From: hda projects [REDACTED]
Sent: 15 January 2021 13:00
To: Kathryn Welch <Kathryn.Welch@arun.gov.uk>
Subject: RE: BE/139/20/CLP The Royal Oak Public House Chichester Road Bersted PO21 5JF

BE/139/20/CLP The Royal Oak Public House Chichester Road Bersted PO21 5JF

Title
Block and Location Plans

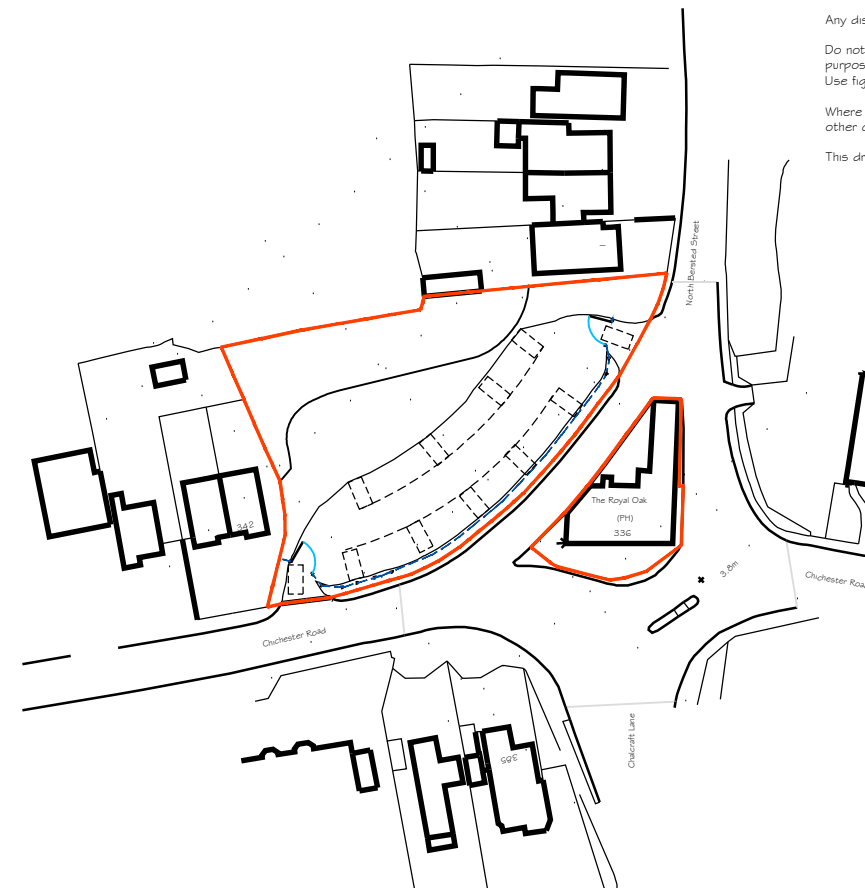
Additionally, as a warning to the applicant, due to the height of the fence I would suspect the Cert. Existing Development would be refused. I would recommend therefore you withdraw the application and submit a full planning application for the proposal. Should you wish to continue with a Lawful development certificate (which I can request is swapped to the correct format) you may, but I would be grateful if you would let me know which way you wish to proceed.

Further to our emails we can confirm the current application should be withdrawn.

We attach substitute application for Certificate of Existing Development that we understand may fall within Schedule 2, Part 2 Minor Operations - Class A of the Planning GDO providing the fence is less than 1.0m high. The site is remote from the Listed Building.
